HOLY CROSS COLLEGE TRANSPORT ASSESSMENT

HOLY CROSS COLLEGE LANDS DEVELOPMENT

Client/Project owner	CWTC Multi Family ICAV acting on behalf of its sub-fund DBTR DR DR1 Fund
Project	Holy Cross College, Drumcondra
Study	Holy Cross College Development – Transport Assessment
Type of document	Draft report
Date	07/07/2021
Reference number	30060314
Number of pages	86

1.6 Pre-Application Consultation SHDPAC 033/20

Drawing file: Transport / SYS-CL-05.1_Swept Path Analysis - Refuse Vehicle. Sheet 1 of 2.pdf

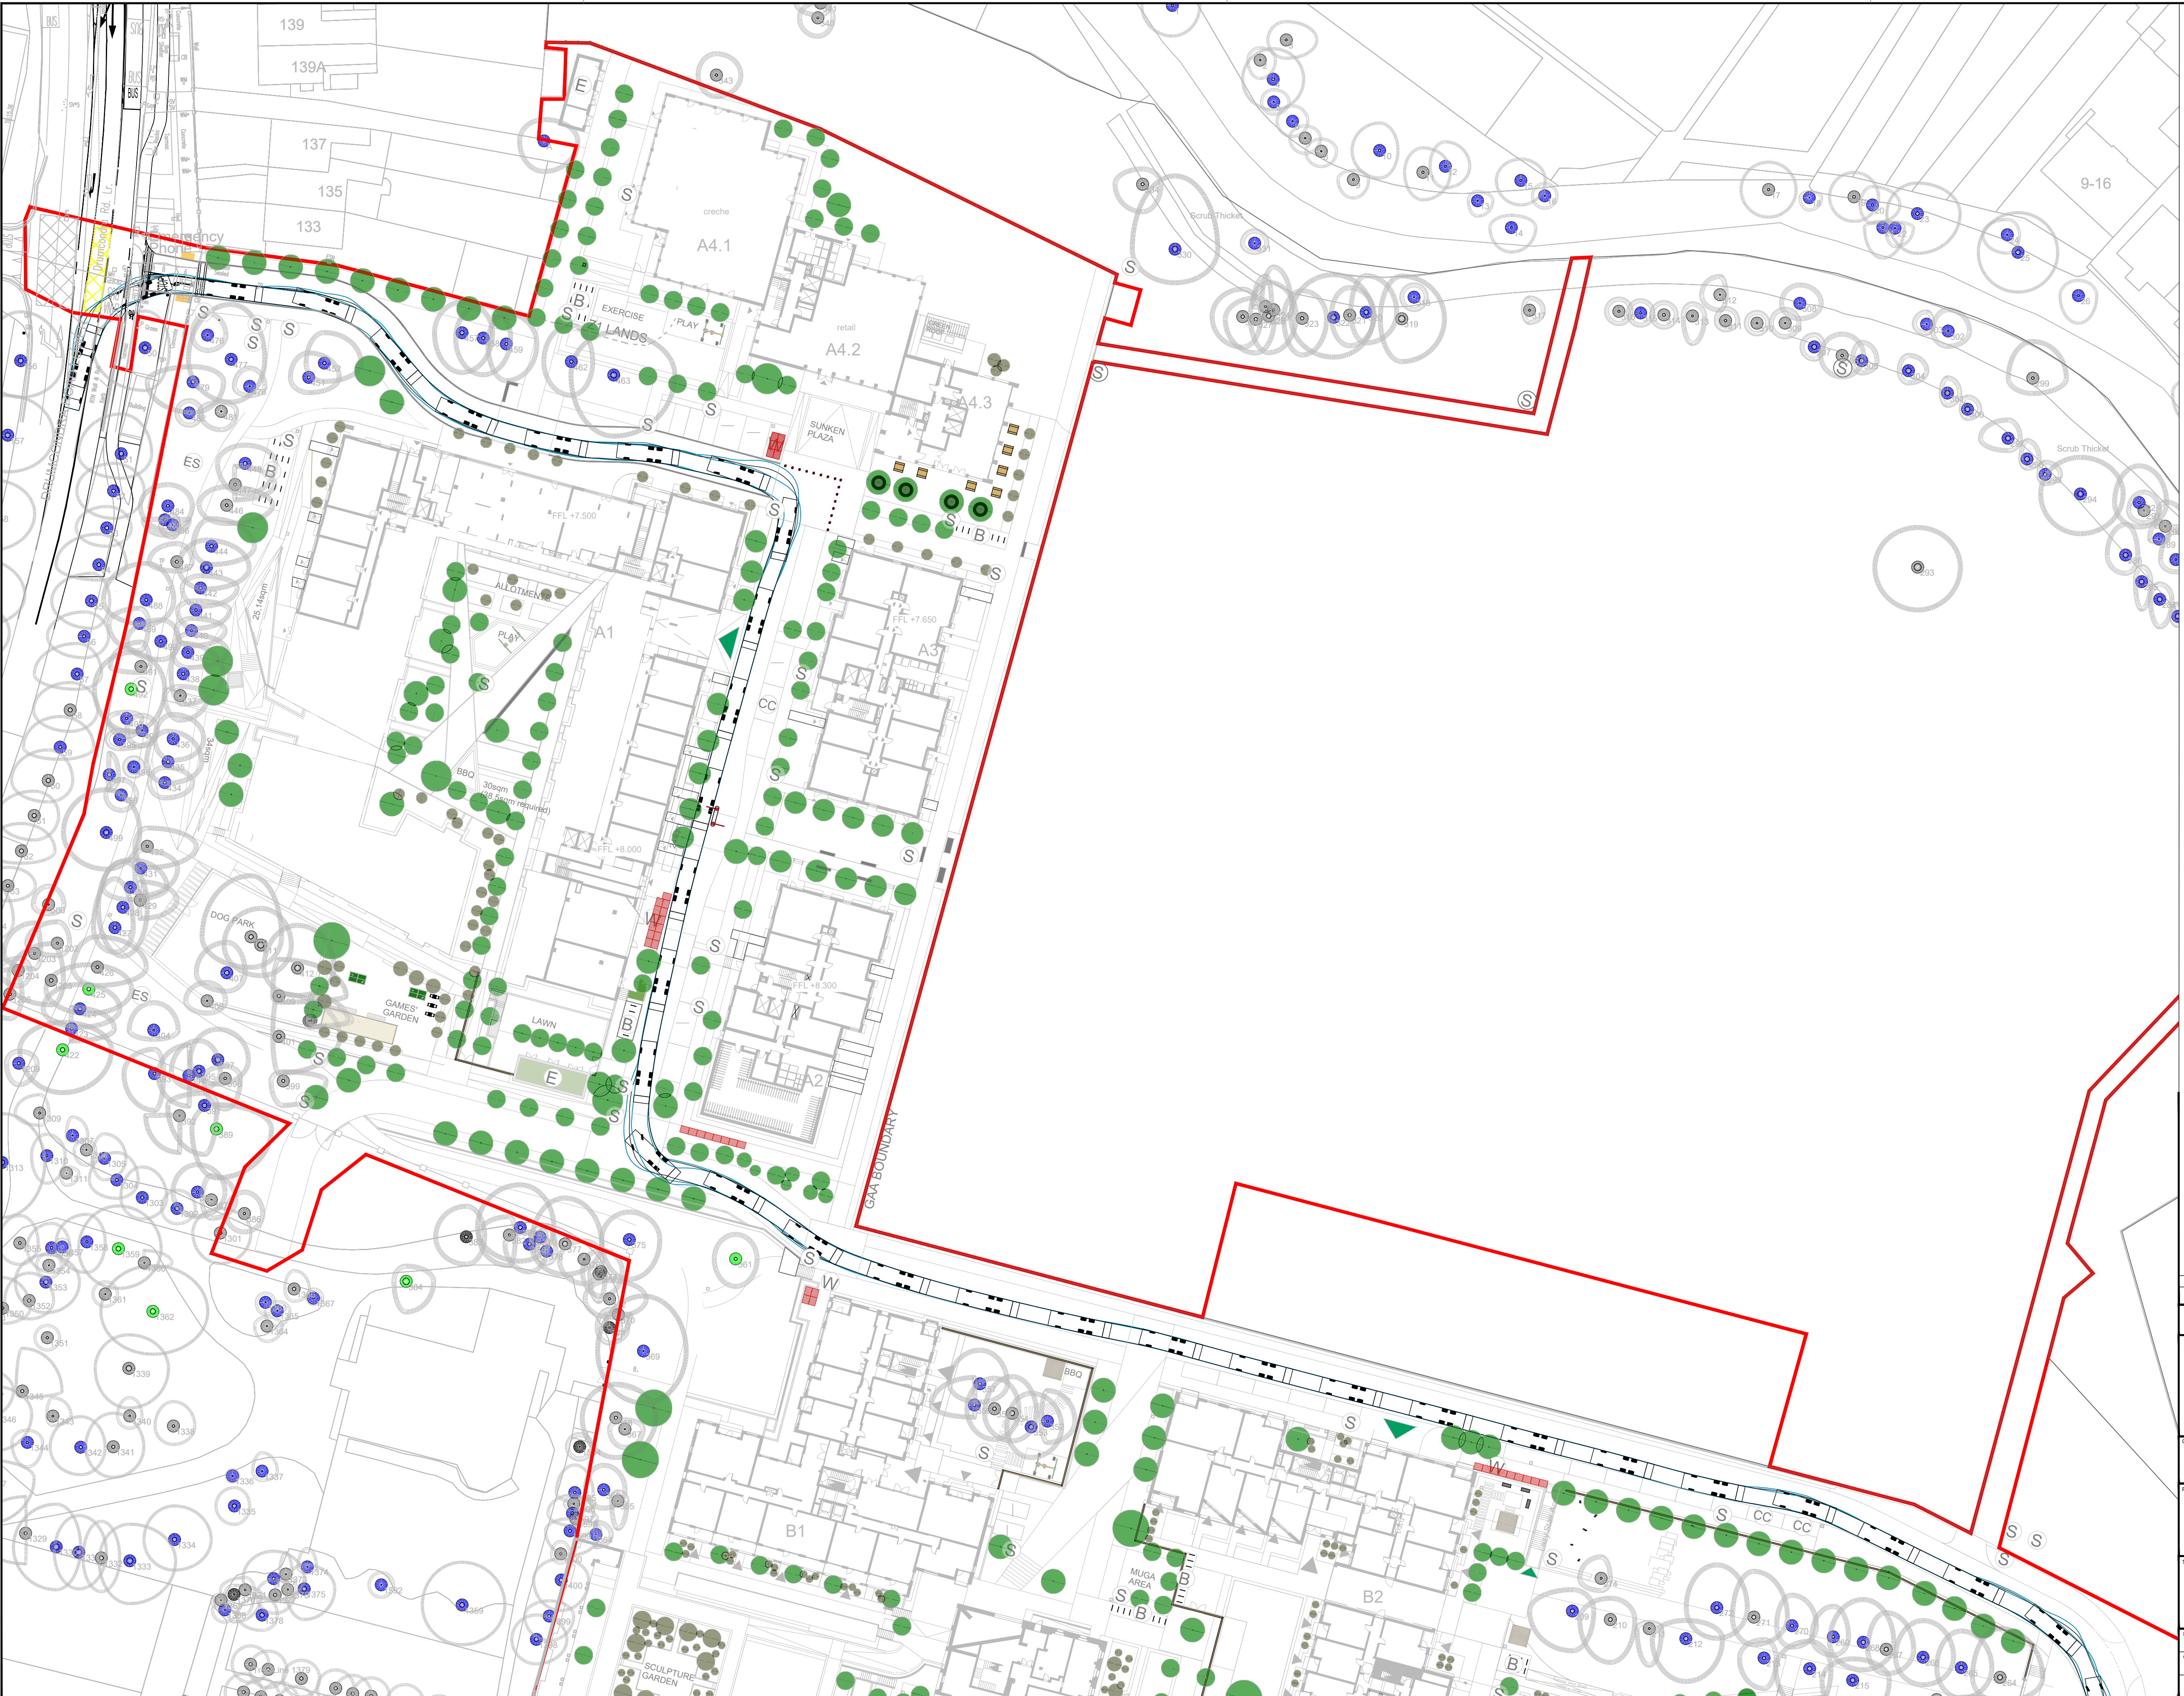
4. **Waste Servicing:** The applicant is requested to clarify details in relation to how the proposed development will be accessed and served by waste management operators. It is unclear if refuse vehicles will have access through the entire site i.e. access at Clonliffe Road and travel through to exit at the Drumcondra Road or vice versa. Figure 29 of the Transport Assessment (TA) indicates full access for refuse/service vehicles through the entire site but the drawings in Appendix A of the TA do not indicate full through access. Furthermore, the bin store area serving the retail unit is located on the northern elevation, away from the access road and does not appear to have ease of access for collection points. Clarity around same is required.

Figure 33 (Figure 29 has been renumbered) and Drawing SYS – CL – 05.1 & 05.2 have been updated to reflect the designated waste collection points and routes for waste collection vehicles.
